From: Richard Castro-Parker <Richard.Castro-Parker@arun.gov.uk>
Sent: 16 December 2019 13:09
To: Planning.Responses <Planning.Responses@arun.gov.uk>
Subject: FW: Application Ref: R/220/19/PL - 2 Ash Lane, Rustington

From: Aarti O'Leary
Sent: 04 November 2019 14:08
To: 'Richard Castro-Parker' <Richard.Castro-Parker@arun.gov.uk>
Subject: Application Ref: R/220/19/PL - 2 Ash Lane, Rustington

DRAWING STATUS	PLANNING
PROPOSED ELEVATIONS & EXTERNAL SEATING AREA

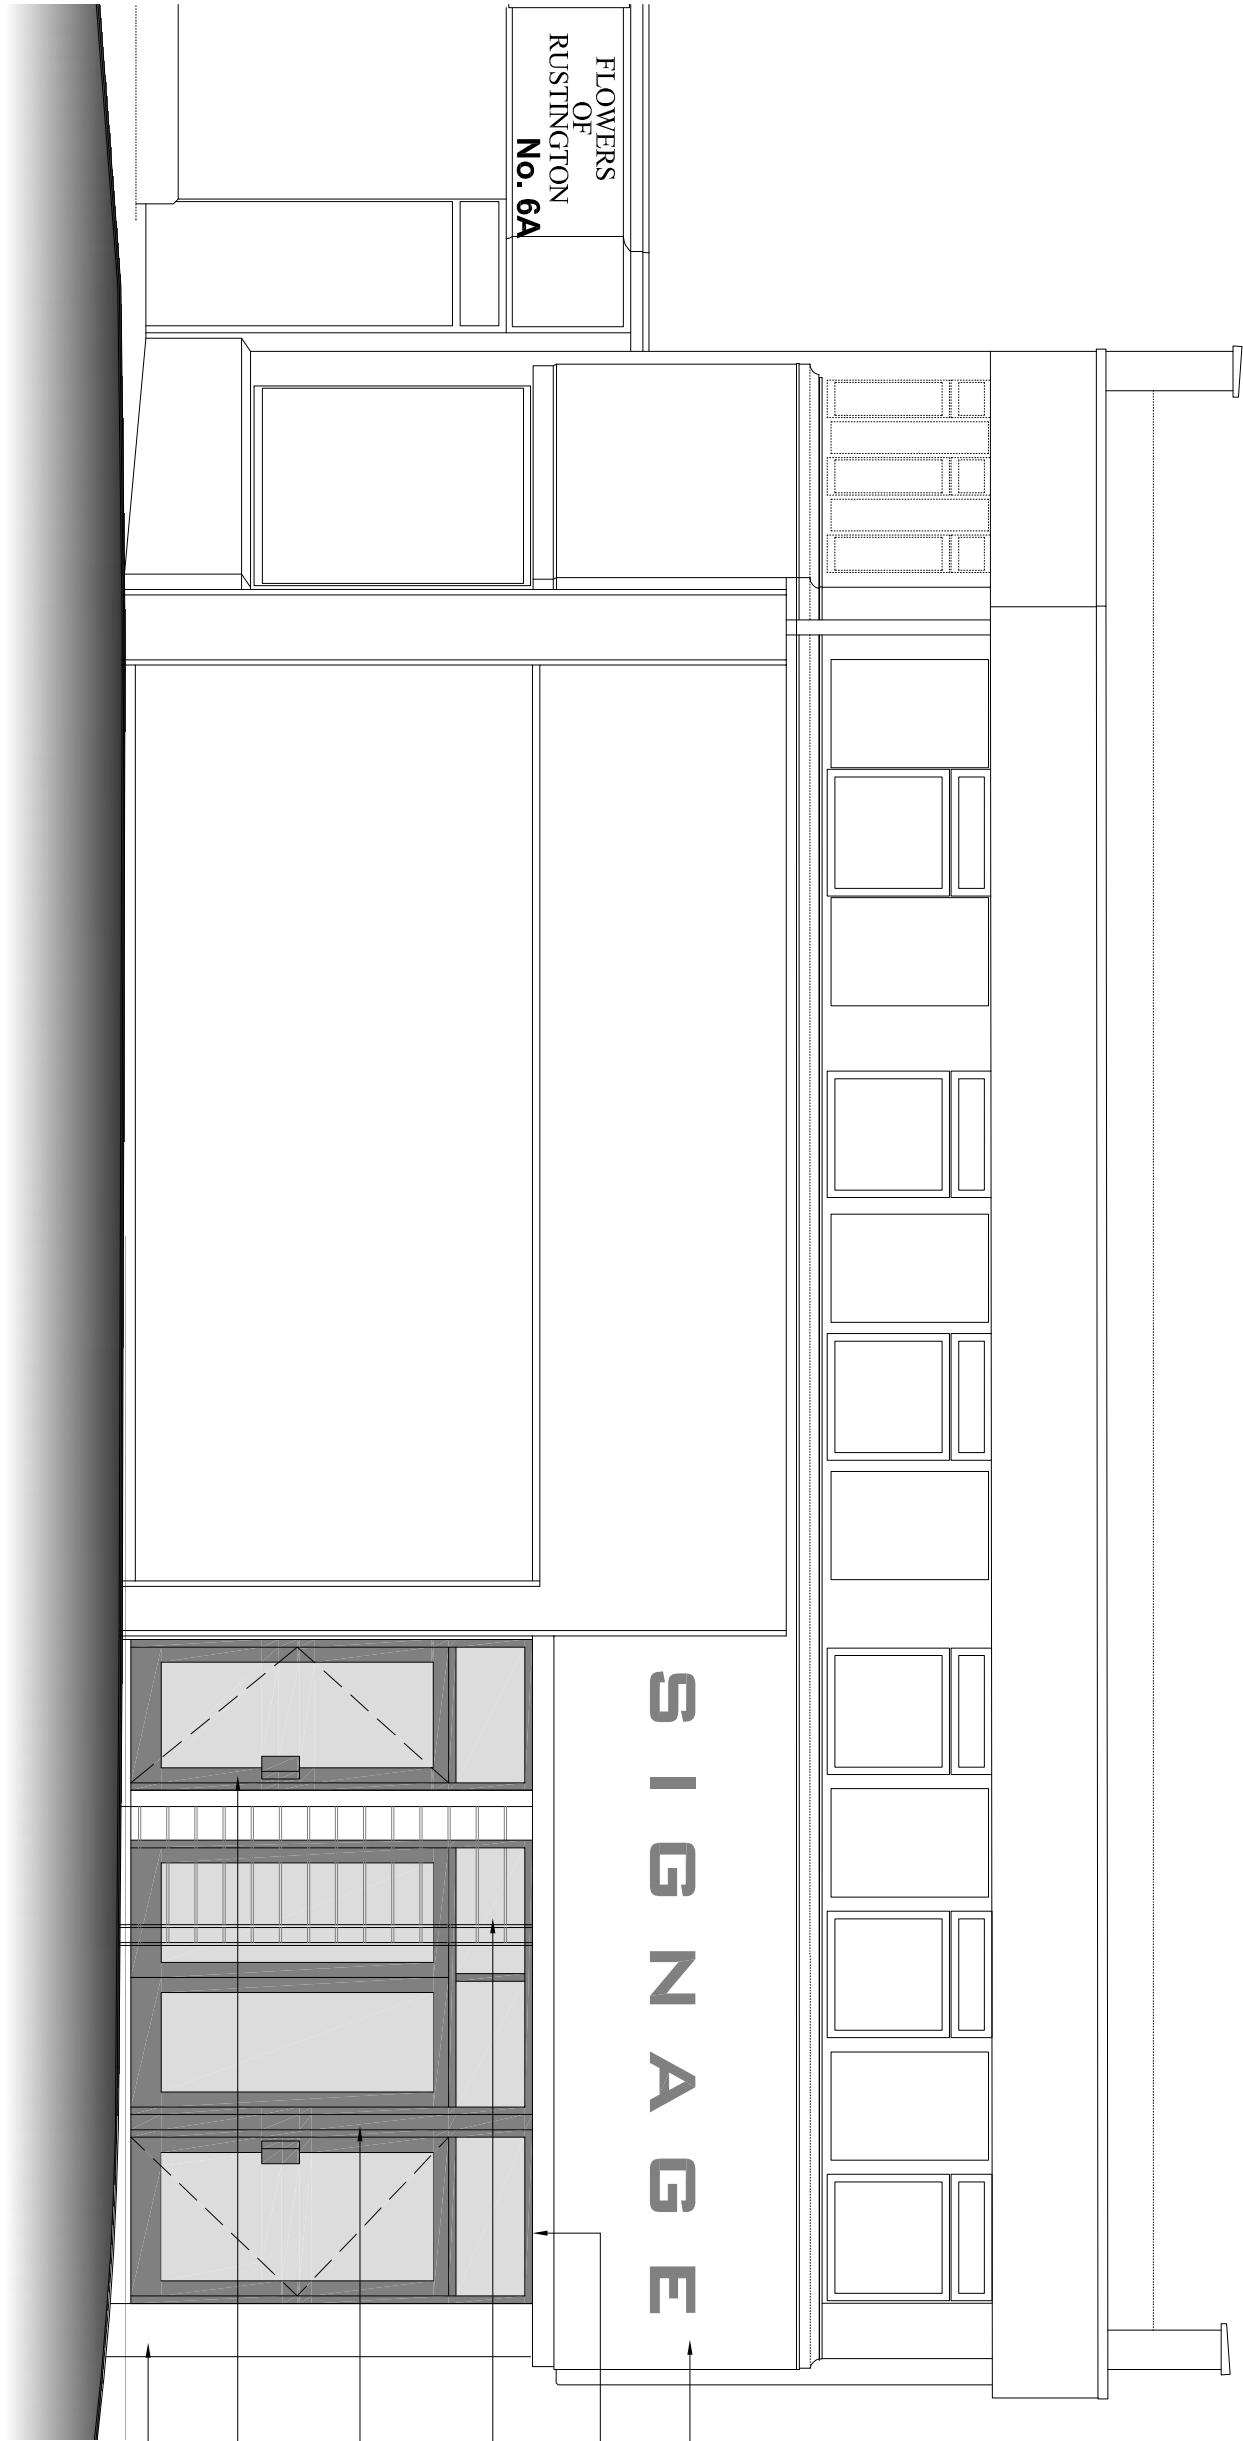
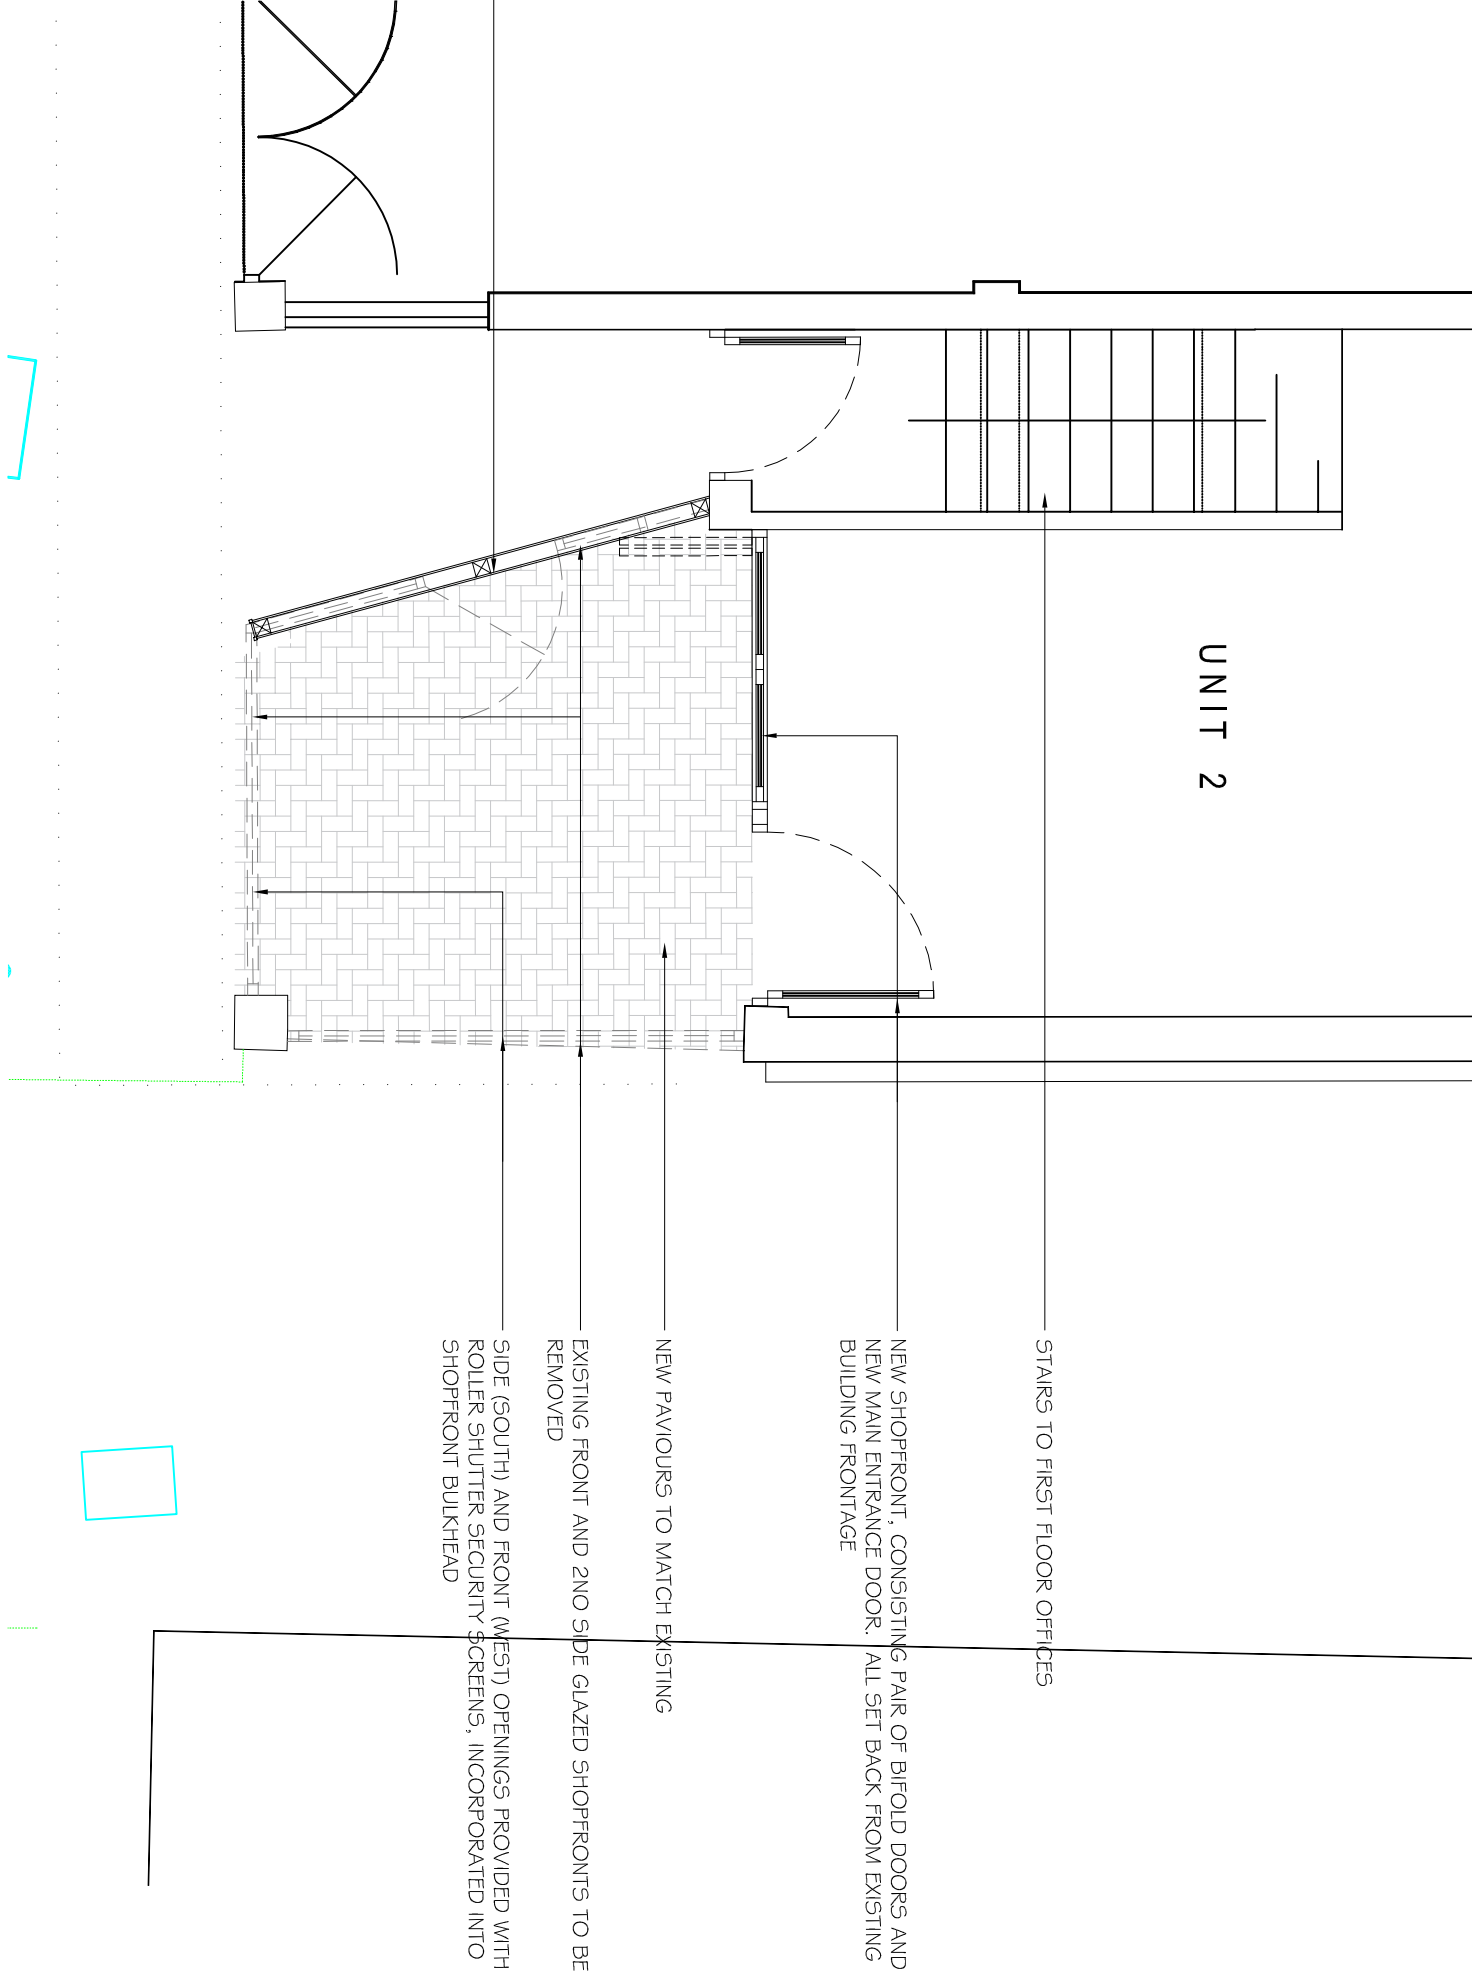
1. A "pavement seating" area is being created within the existing building and does not use any of the pavement in front of the existing building.
This is correct. the existing glazing of the shop front is being replaced by a covered trading area with the seating only in this area.
2. There is a solid partition between the building and our entrance (the wall currently with a door to the Halifax building).
Correct – this is being a hard frontage to prevent overspill as per the plan.
3. There will be barriers in front of the seating area (facing Ash Lane) to stop people spilling out onto the pavement and congregating in front of the entrance to our offices.

- The proposed seating area does not use any of the pavement in front of the existing building;
- There is a solid partition between the application site and the entrance to the first floor offices;
- The proposals are such that patrons would not be able to spill out onto the pavement or congregate in front of the entrance to the first floor offices.

Correct – it will also have a roller shutter door to prevent homeless people front residing when out of hours.
